MEMORANDUM

SUBJECT: Mifflin SEG-07-29

DESCRIPTION: Administrative Segregation in the Commercial Ag Zone.

SUBJECT: Mifflin SEG-07-29. 17-20-30000-001, -0002.

**CRUSE & ASSOCIATES**  
PROFESSIONAL LAND SURVEYORS  
217 East Fourth Street P.O. Box 959  
Ellensburg, WA 98926 (509) 962-8242  
**MIFFLIN PROPERTY**

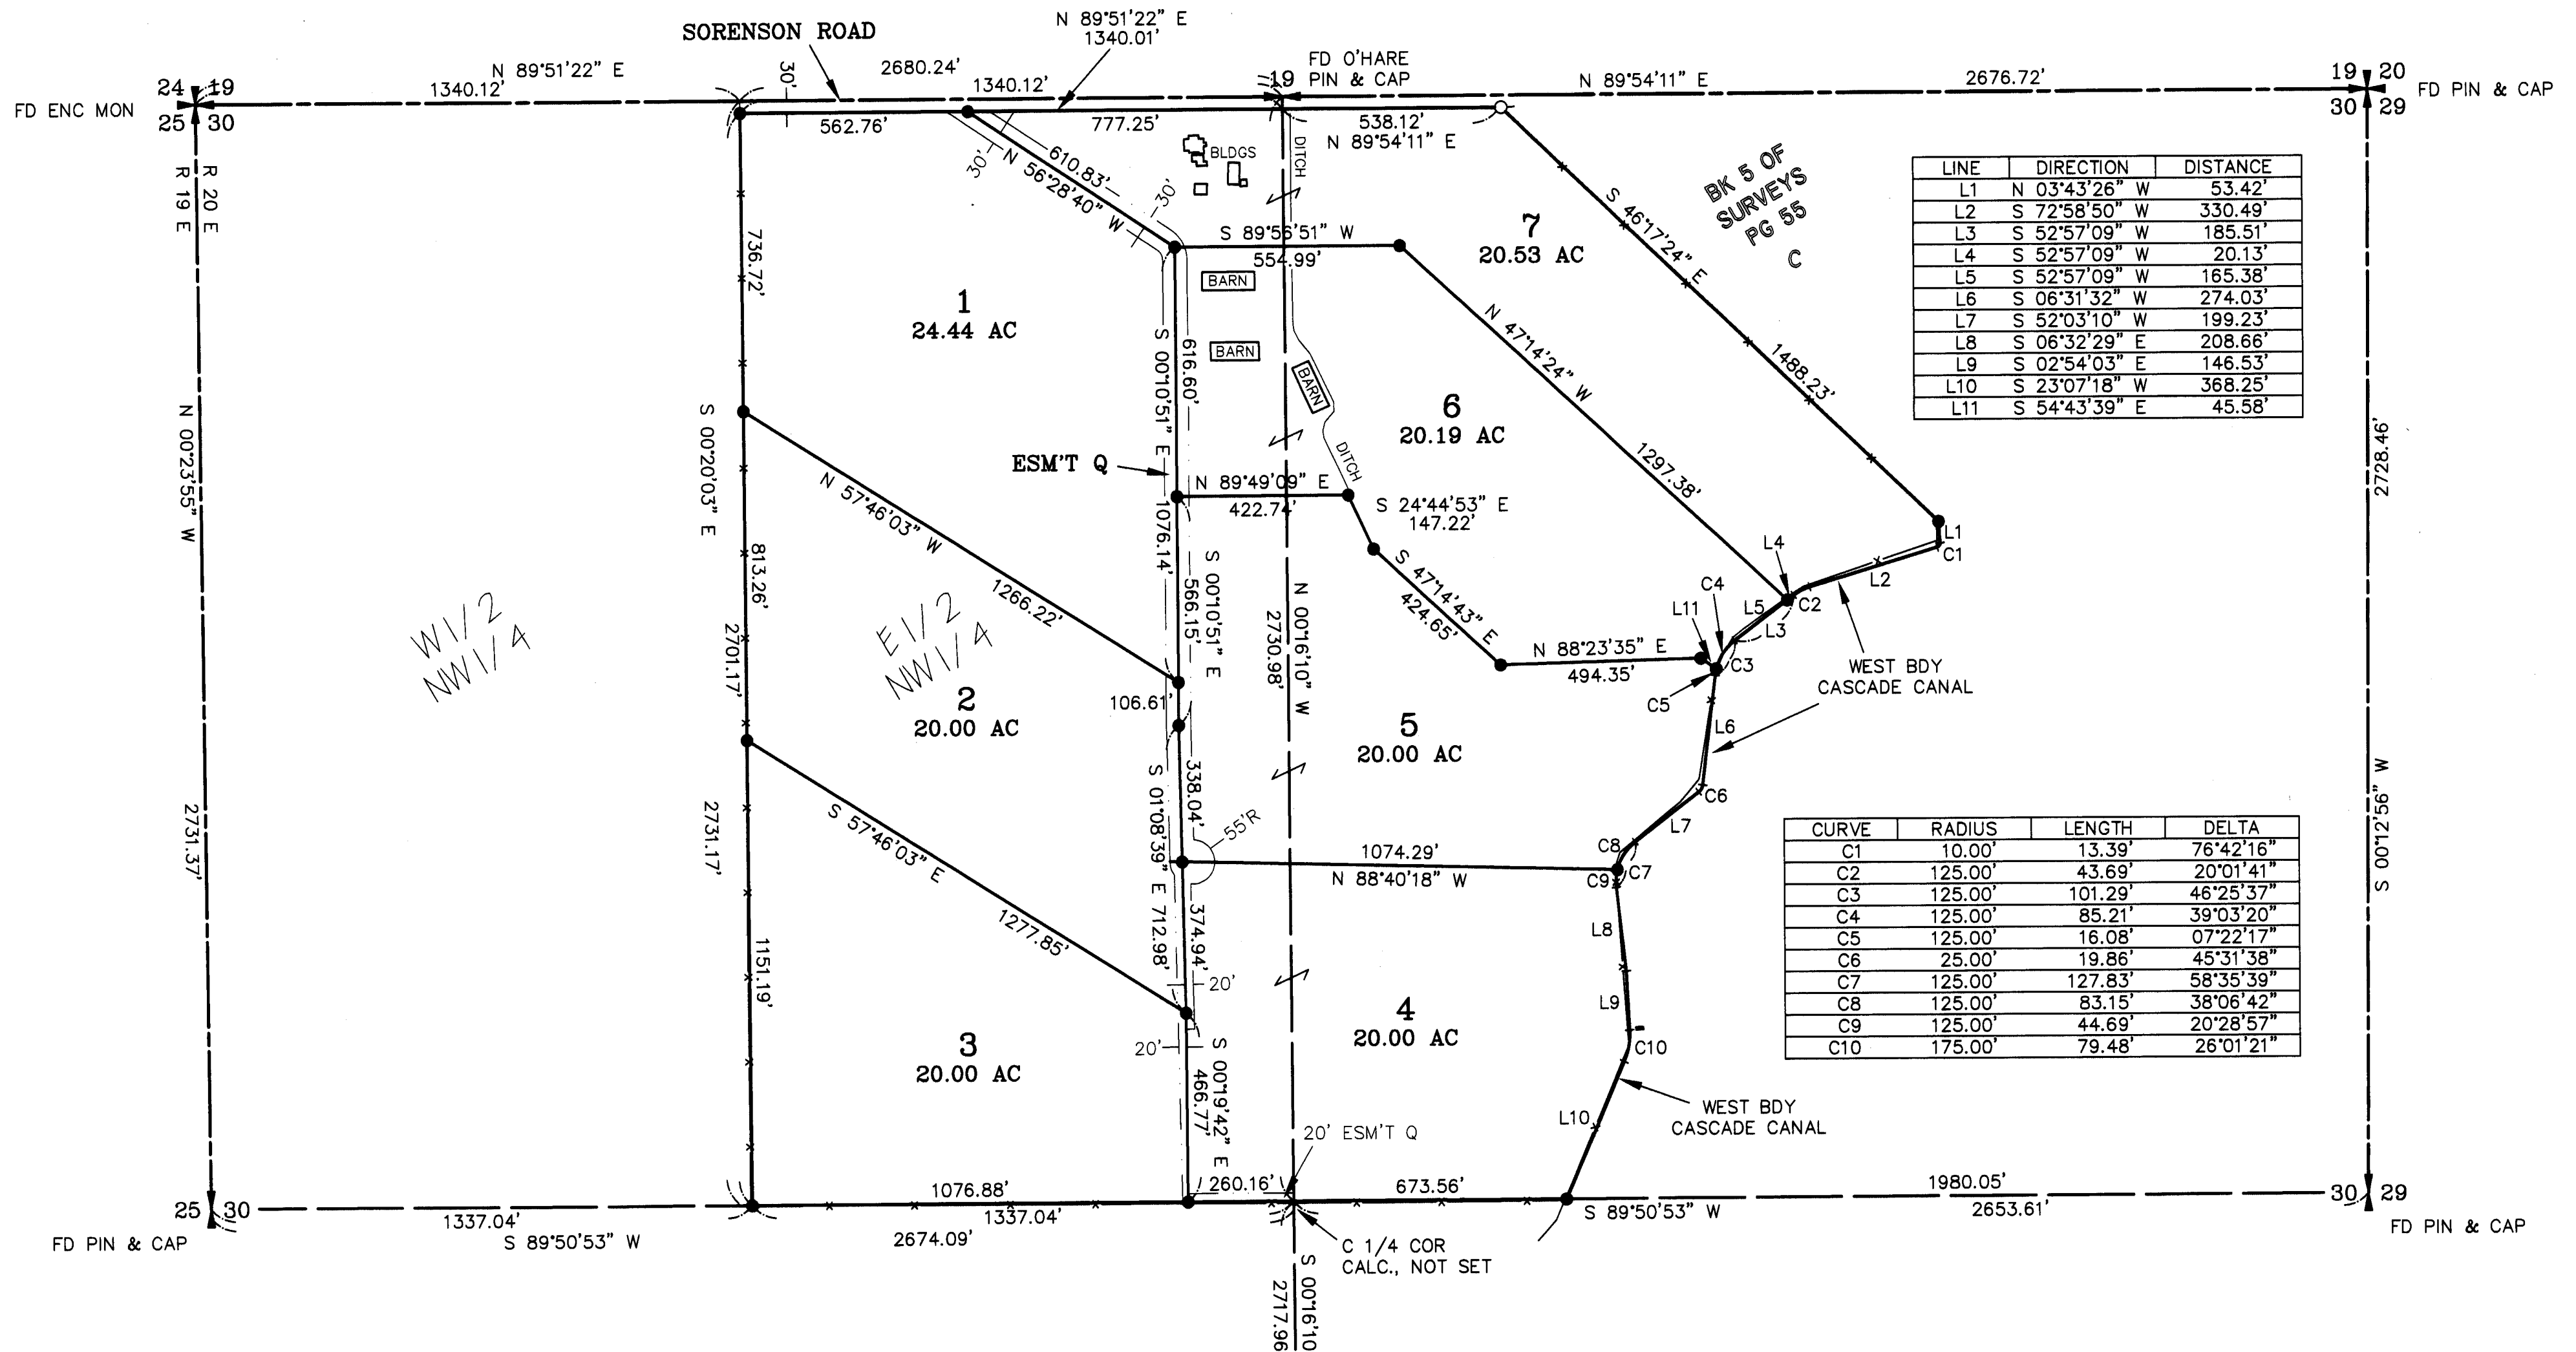
2. Private Road Improvements: Access shall be constructed as a Low-Density Private Road. See Kittitas County Road Standards, 9/6/05 edition.
 - a. Access easements shall be a minimum of 60' wide. The roadway shall have a minimum width of 20', with 1' shoulders, for a total width of 22'.

- b. Minimum centerline radius will be 60'.
 - c. The surface requirement is for a minimum gravel surface depth of 6".
 - d. Maximum grade is 12%.
 - e. Stopping site distance, reference AASHTO.

- j. All easements shall provide for AASHTO radius at the intersection of county road.
 - k. A paved apron shall be constructed at the intersection of the proposed private intersection and the county road right of way.

3. Cul-de-Sac: Permanent deadend streets shall have a turn-around having an outside right-of-way easement diameter of at least 110' (55' radius) at the closed end. See Kittitas County Road Standards, 9/6/05 edition.
